From: [REDACTED]
Sent: 14 January 2021 16:12
To: ENC PLANNING
Subject: FW: NE/21/00012/FUL

Subject: NE/21/00012/FUL

I note that the proposal includes the addition of a front porch, may I therefore suggest a small change to the description to "Two storey extension to side and rear, reducing to single storey on rear elevation and addition of front porch." Please confirm in writing that you are happy with the amended description as given above. This amendment is suggested as descriptions for applications need to be clear, concise and precise.

86 Highfield Road
N.W. 4th
Side Elevation
Scale 1:100

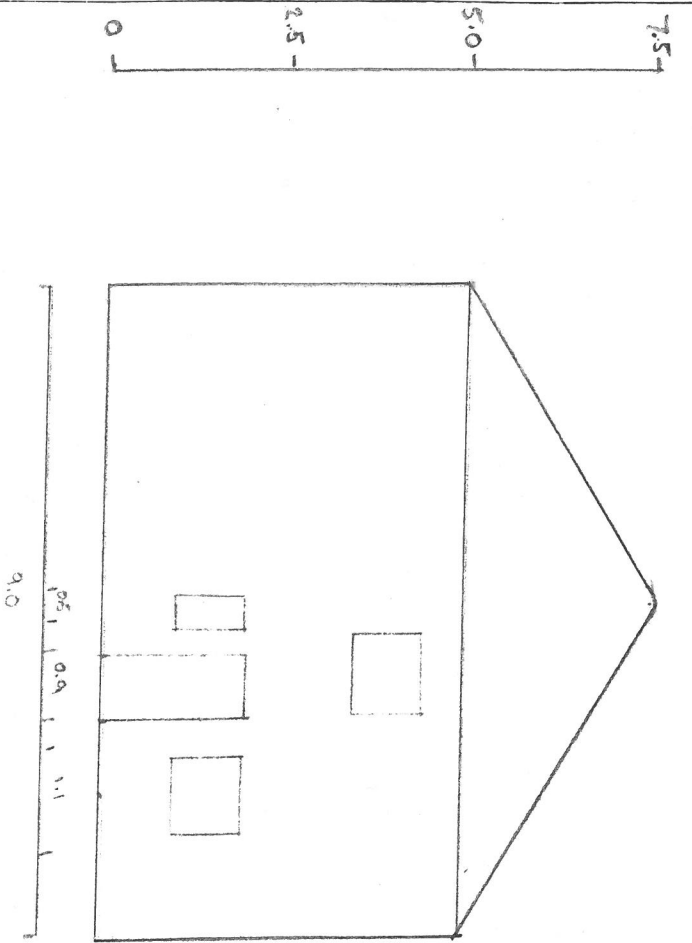
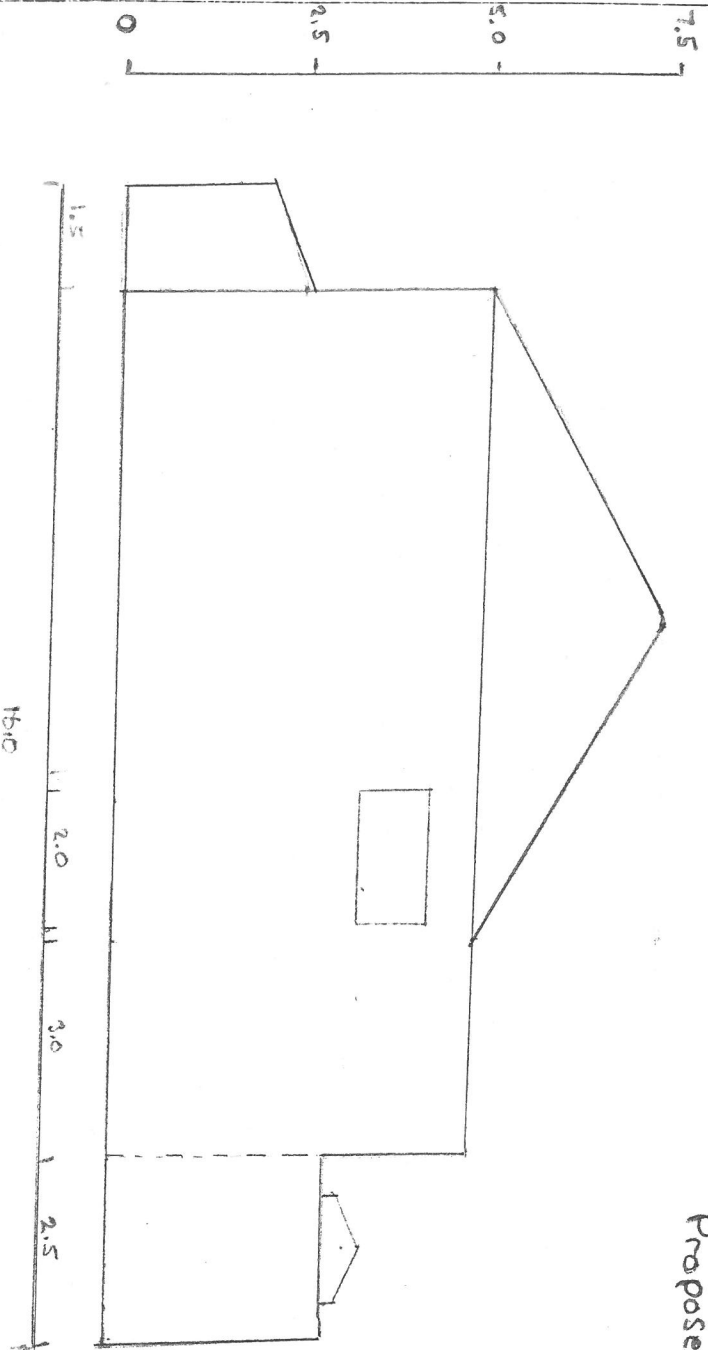
I also note that the dimensions for the side elevations have been cut out off the page and the lines on the proposed site plan are a bit faint, could you email these drawing again please

Also, I have revised the two drawings raised below and these have been uploaded on to the planning portal.
